October 16, 2023

**RE: 142 40<sup>th</sup> St. SW**  
**Grading and Drainage Plan**  
**Engineer's Stamp Date: 10/05/23**  
**Hydrology File: K12D037**

September 14, 2023

**RE: 142 40<sup>th</sup> St. SW**  
**Grading and Drainage Plan**  
**Engineer's Stamp Date: 09/05/23**  
**Hydrology File: K12D037**

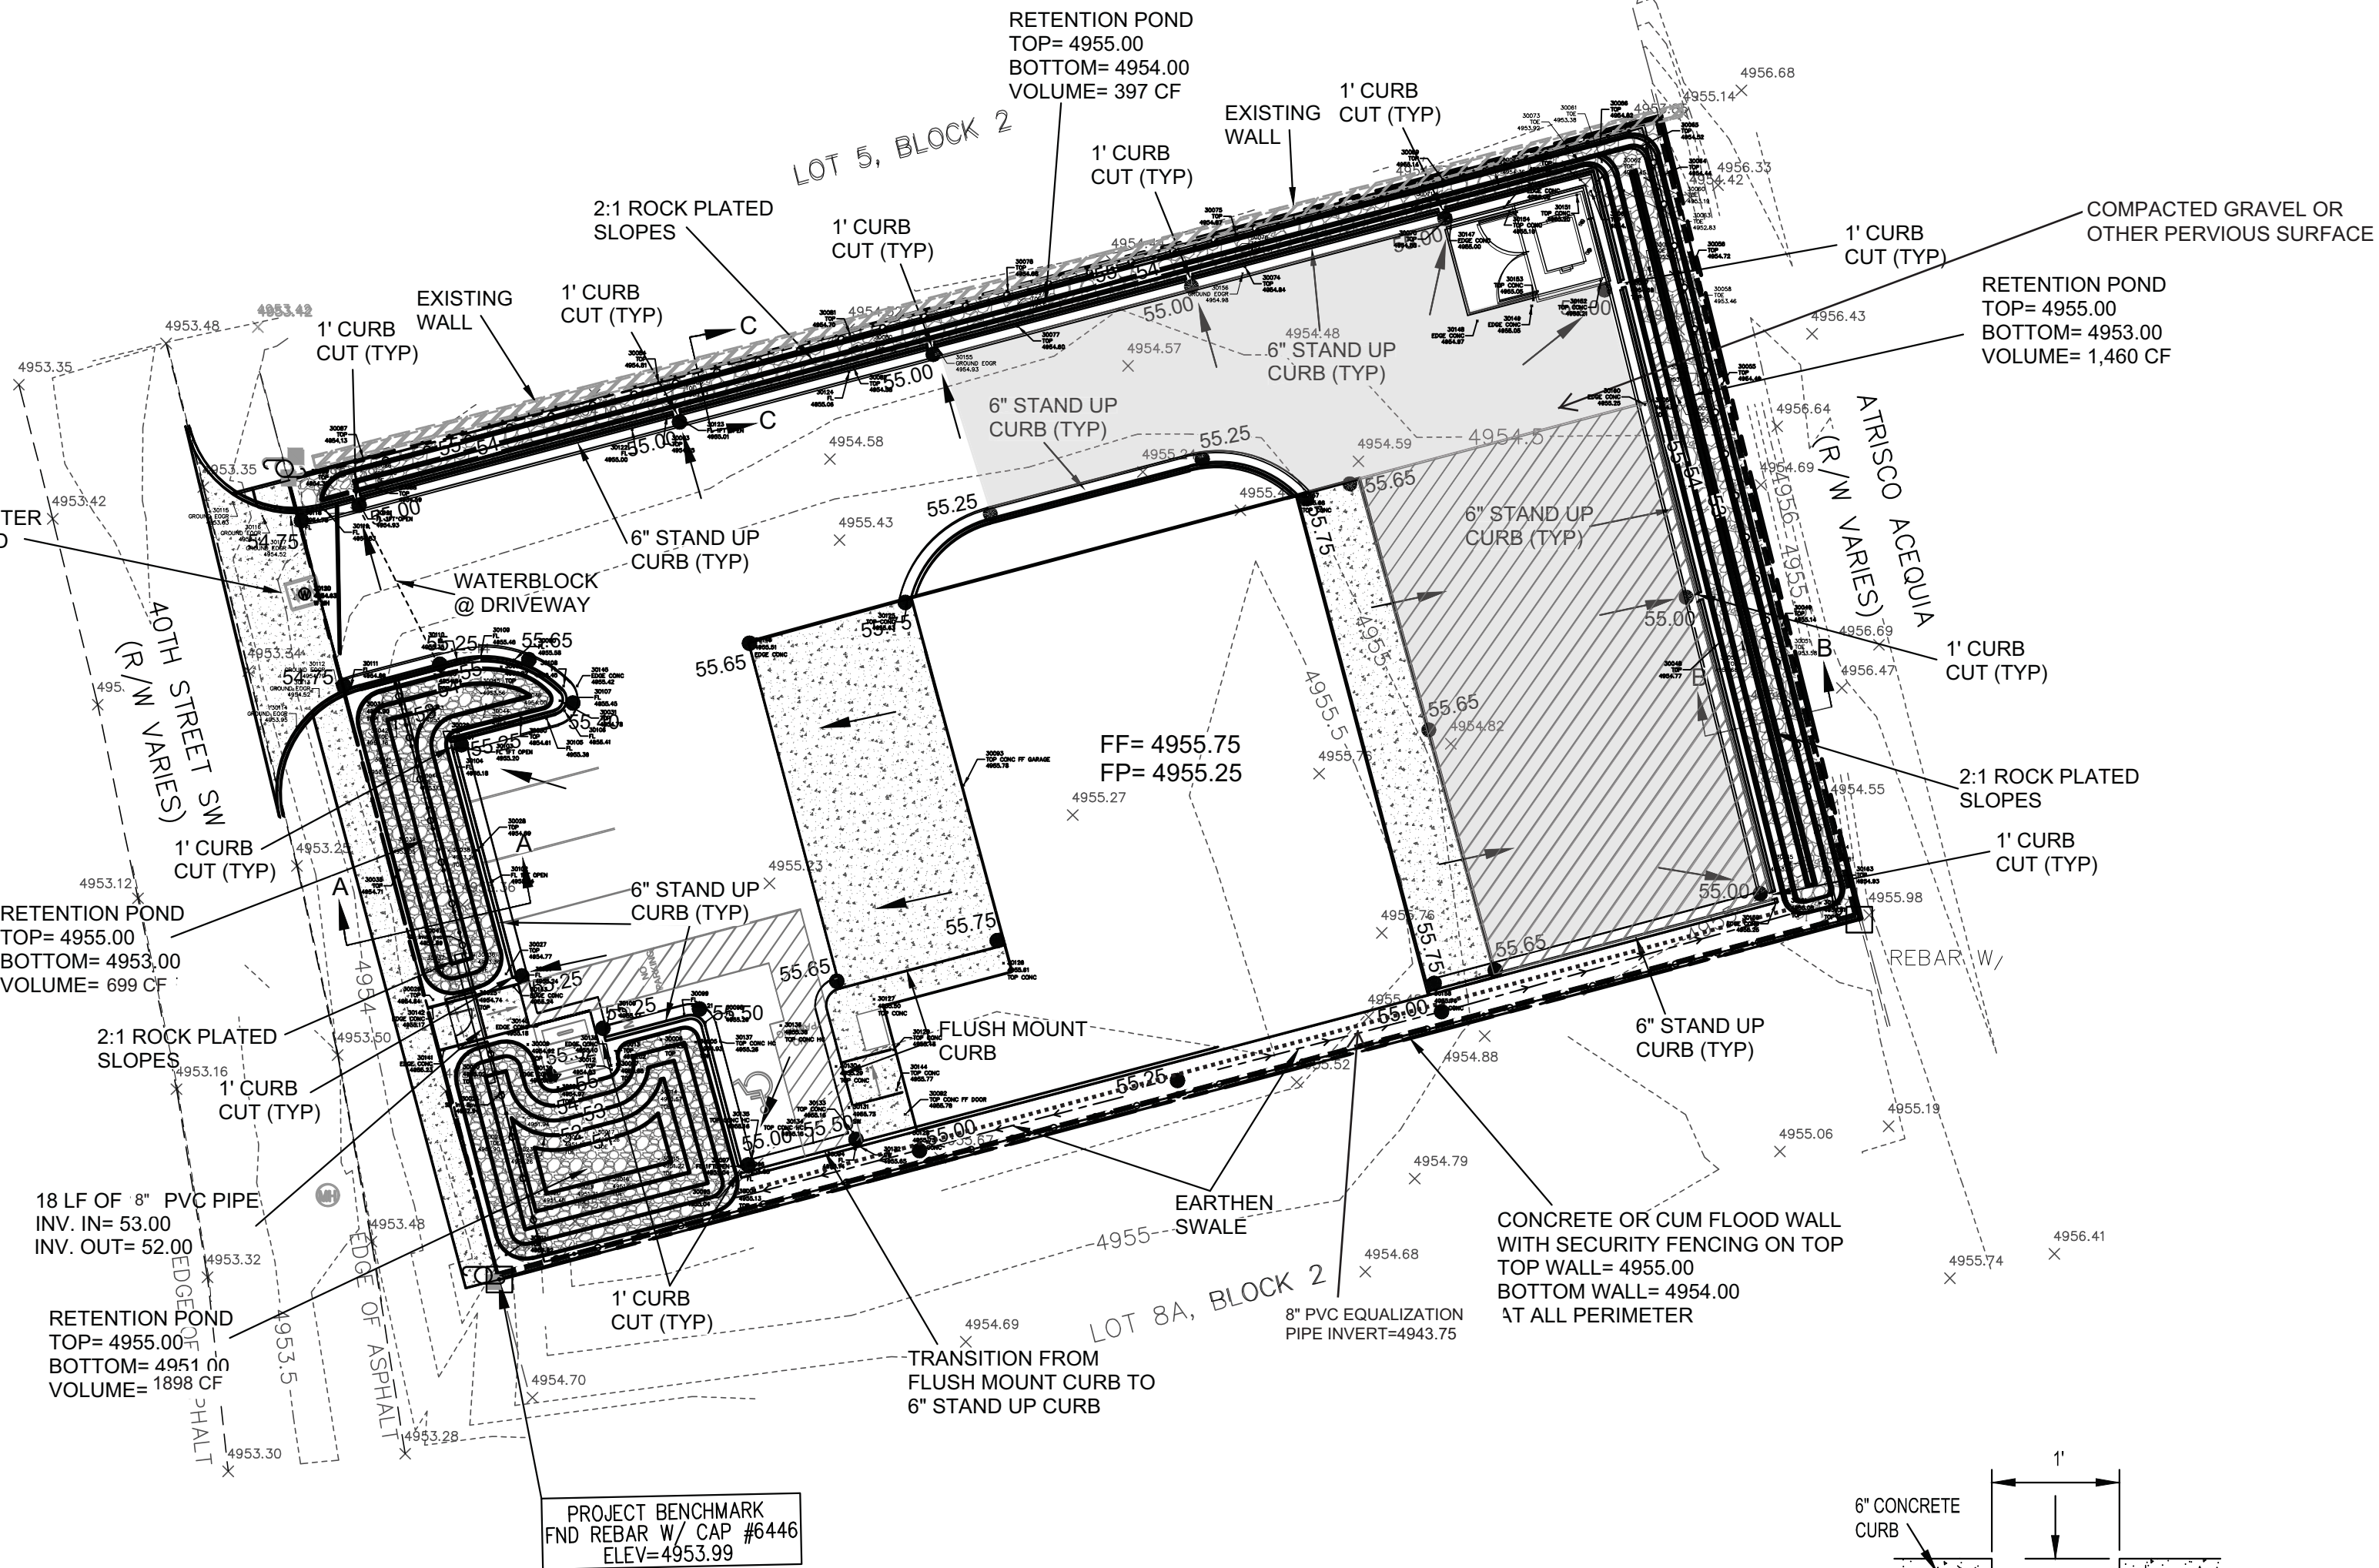
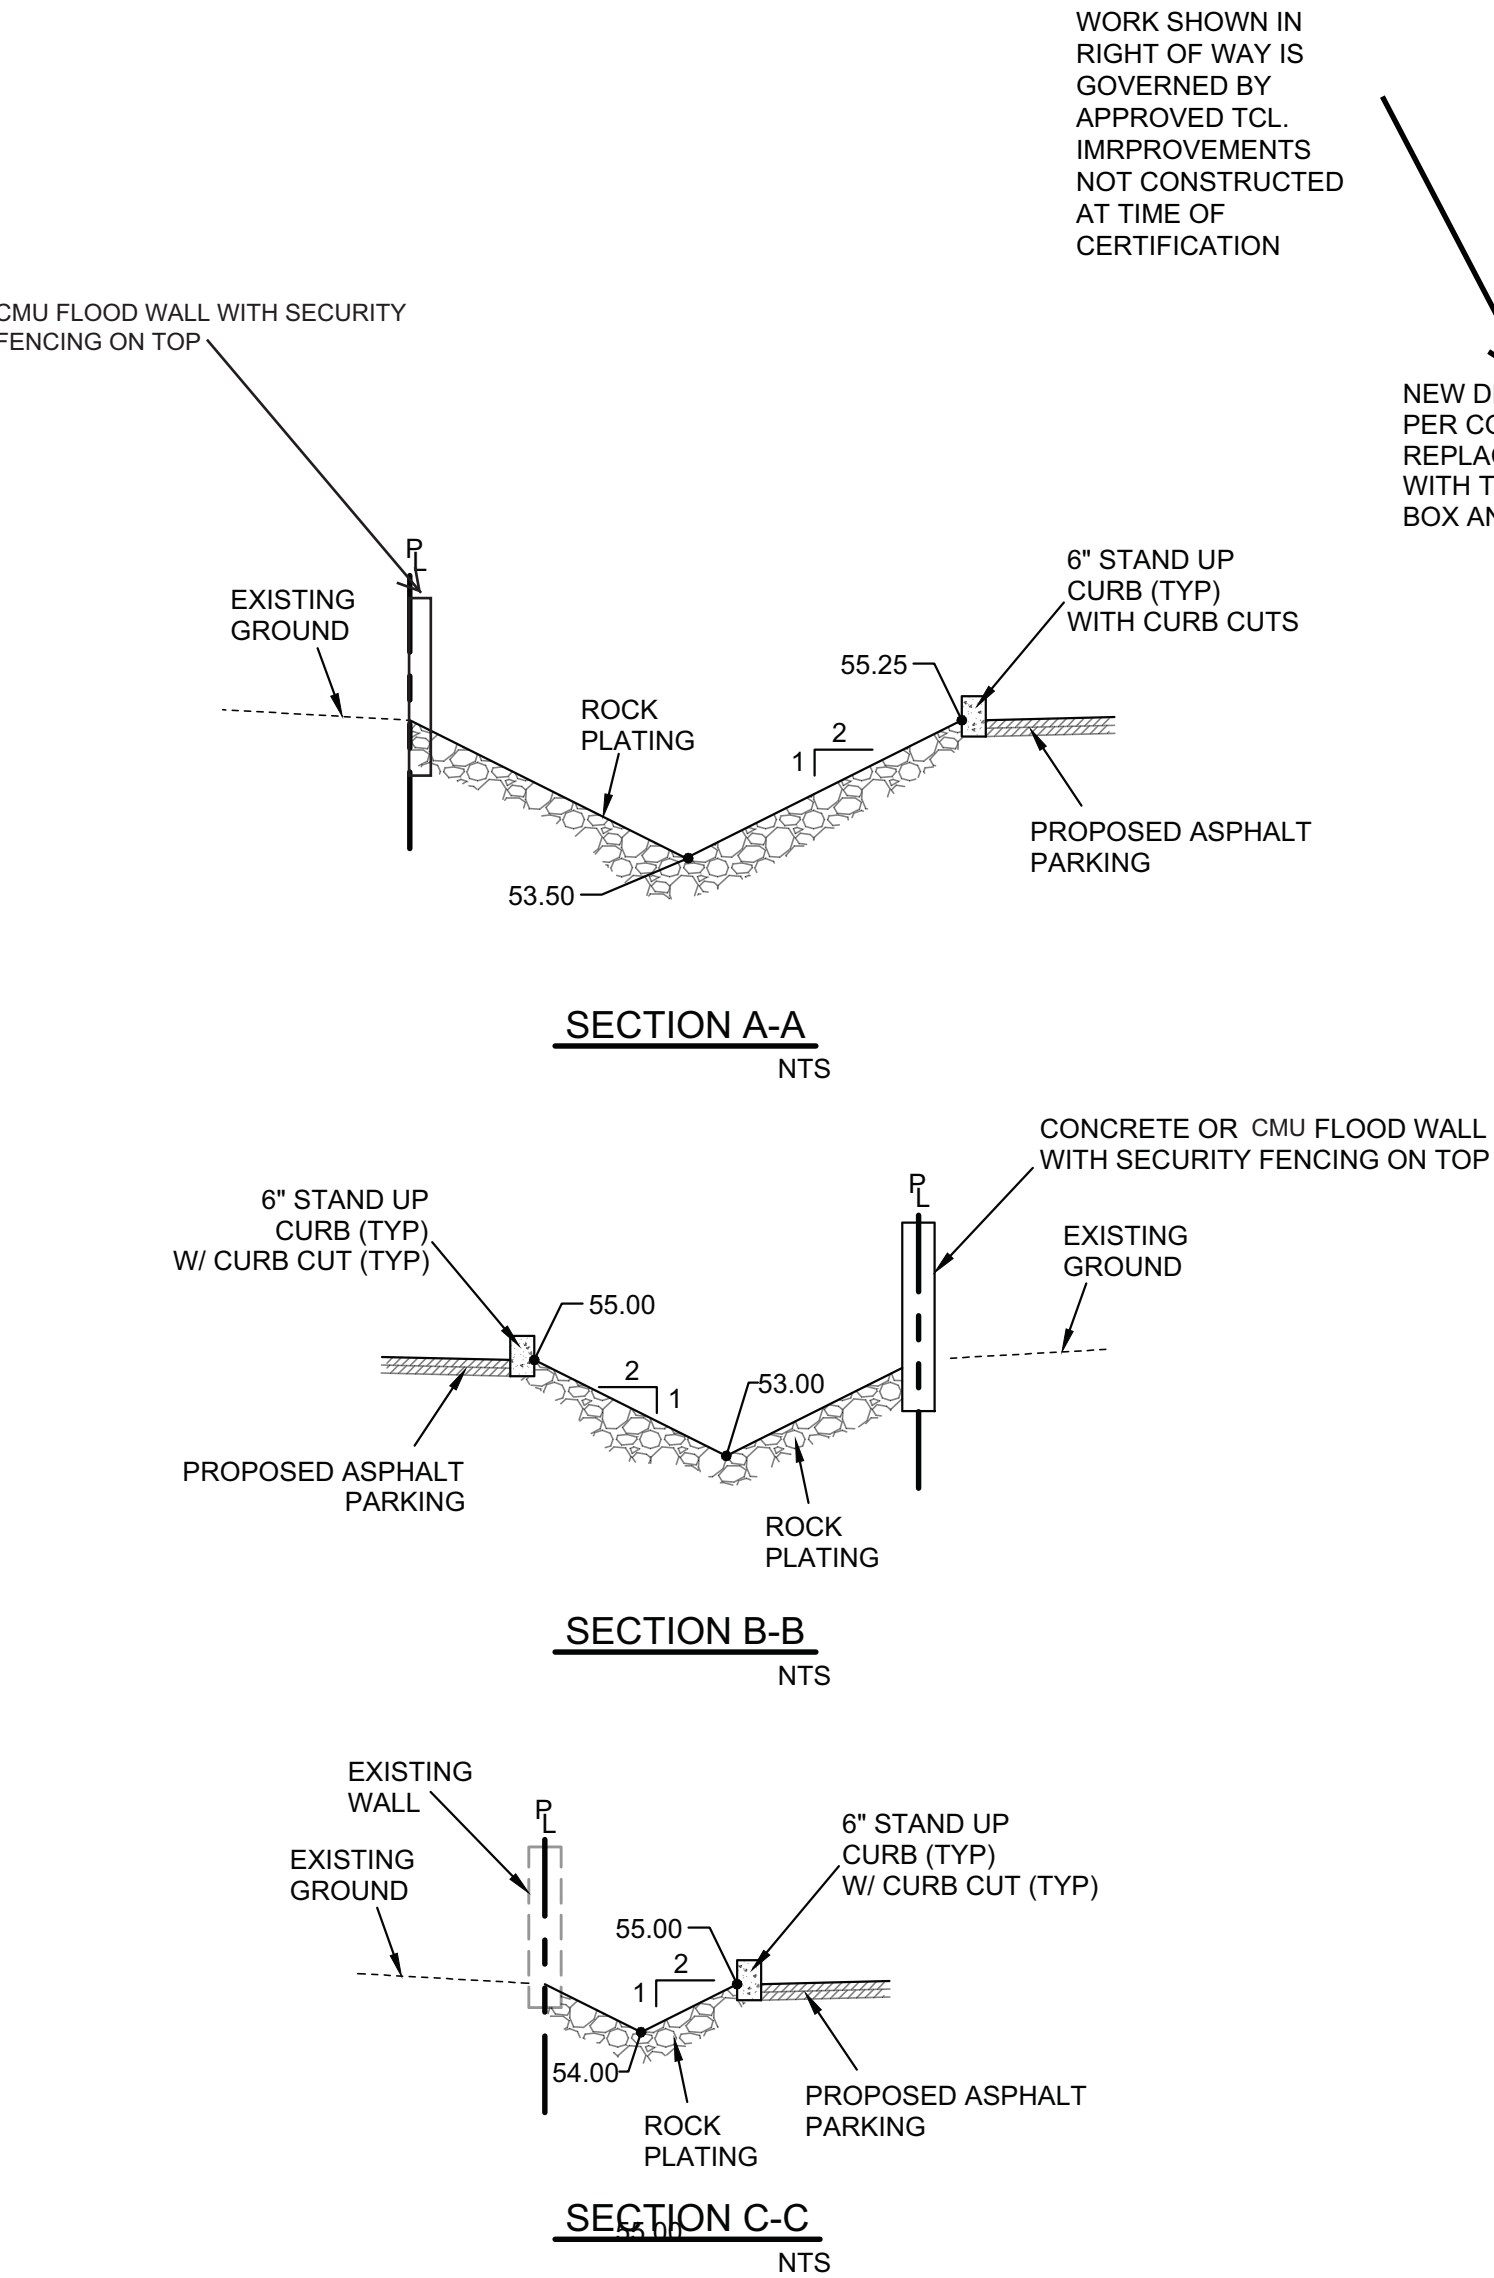
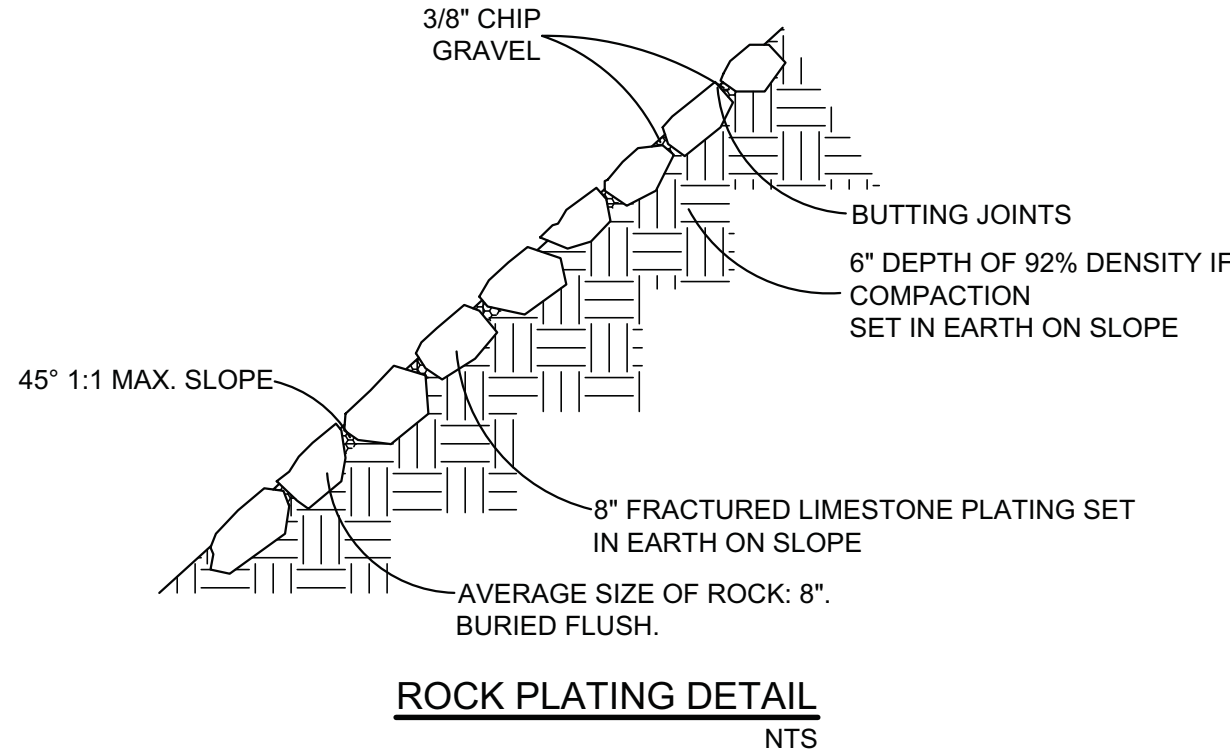
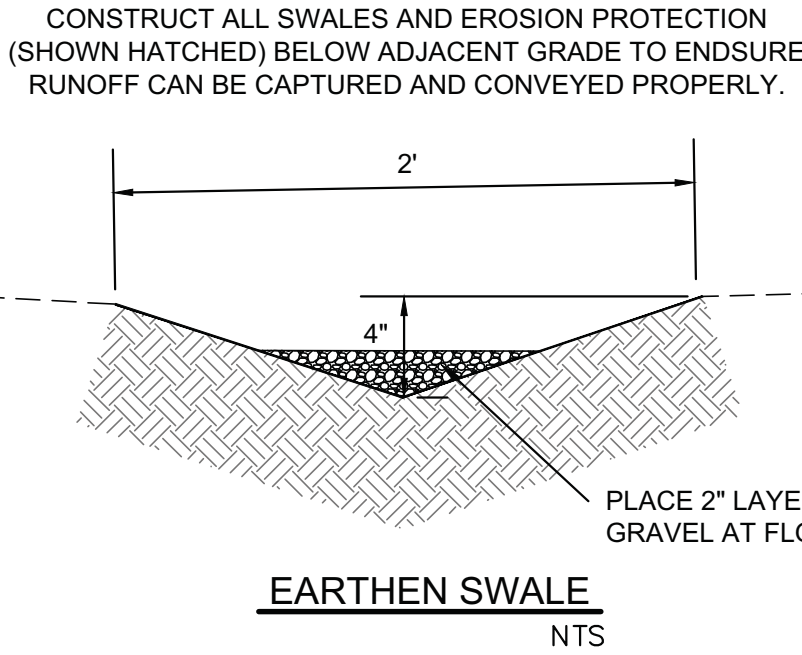
1. Please provide the stormwater quality calculation, multiply the impervious area by 0.26 inches for redevelopment sites. **CORRECTED**
2. please follow Article 6-5 Valley Drainage Criteria of the DPM. The following conditions must be applied to the site:

- a. The maximum percent impervious of the lot and the contributing area may not be greater than 45%. **REDUCED TO 44% BY REPLACING REAR WITH GRAVEL**

- b. Pad elevation shall be a minimum of one (1) foot above the 100 year 10-day stormwater surface elevation. **THIS IS COMMERCIAL, THE ADA PREVENTS US FROM RAISING PAD. THE LOT OVERFLOWS TO SURROUNDING AREA. THIS FUNCTIONS IN ACCORDANCE TO THE STANDARD**

- c. The flow between the front yard and back yard cannot be obstructed. The stormwater must be allowed to equalize to the same level between the front yard and back yard. **PROVIDED**

- d. A permanent perimeter wall or barrier around the development is required to contain the 100 year 24 hour storm developed runoff. **WALL DETAILS SHOW**

- e. The high point of the street should be four inches above the 100 year 10-day stormwater surface elevation. **THE SITE IS EXISTING AND HIGHER THAN THE SURROUNDING AREA**

- f. The retention pond is the 100 year 10-day volume and not the 100 year 24 hour volume. **CORRECTED**
